Application for Planning Permission for Works or Extension to a Dwelling

Development: Proposed Garage.
Location: 16 Sea Way Middleton-On-Sea PO22 7SA

Proposed East Elevation

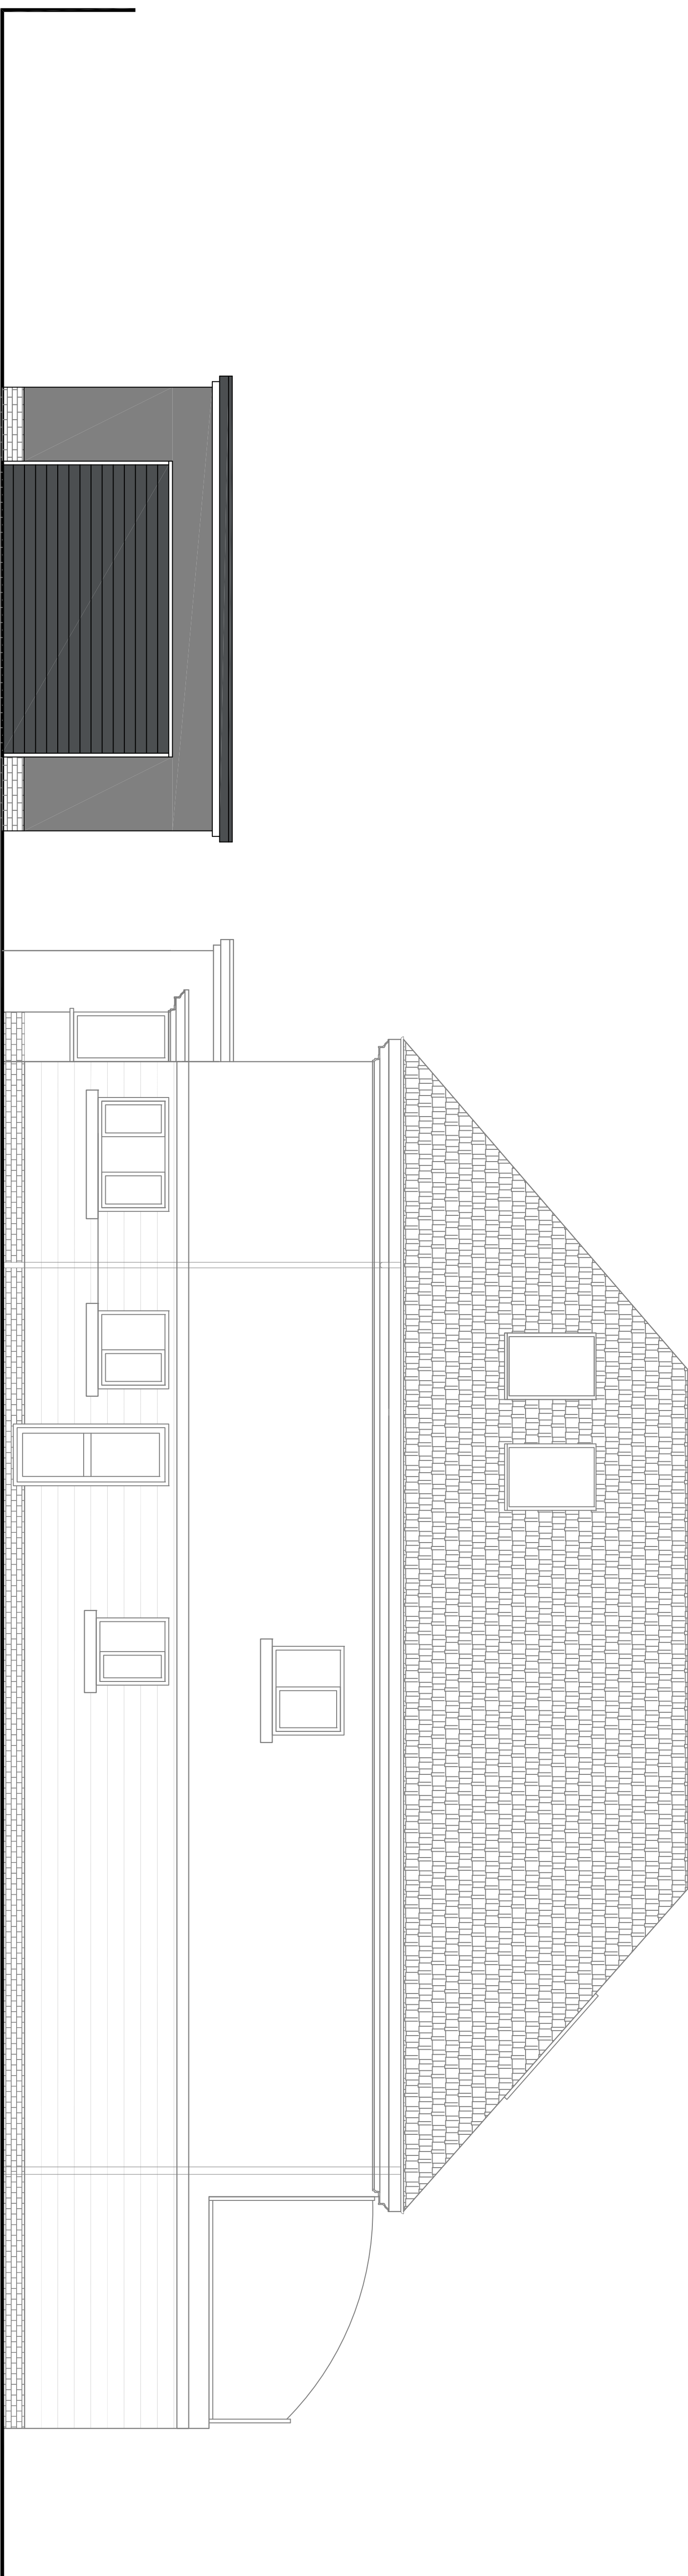
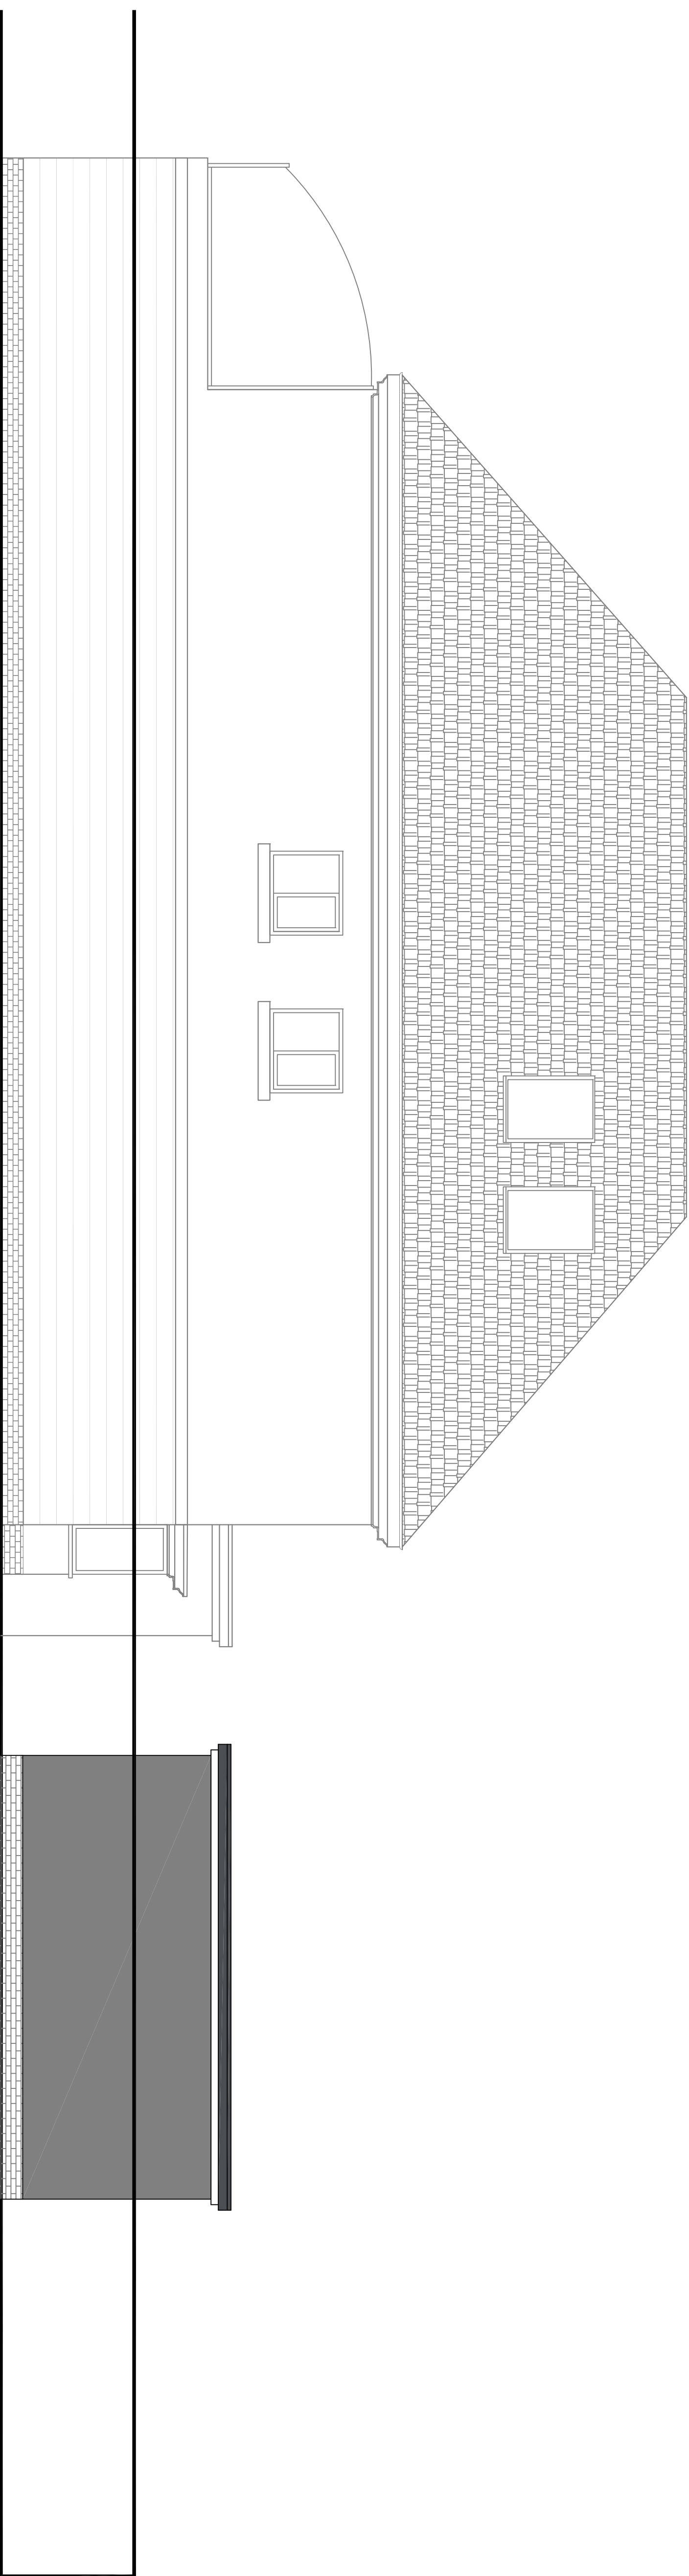
The width and depth of the garage is inconsistent between the plans and the elevations, please review and amend.
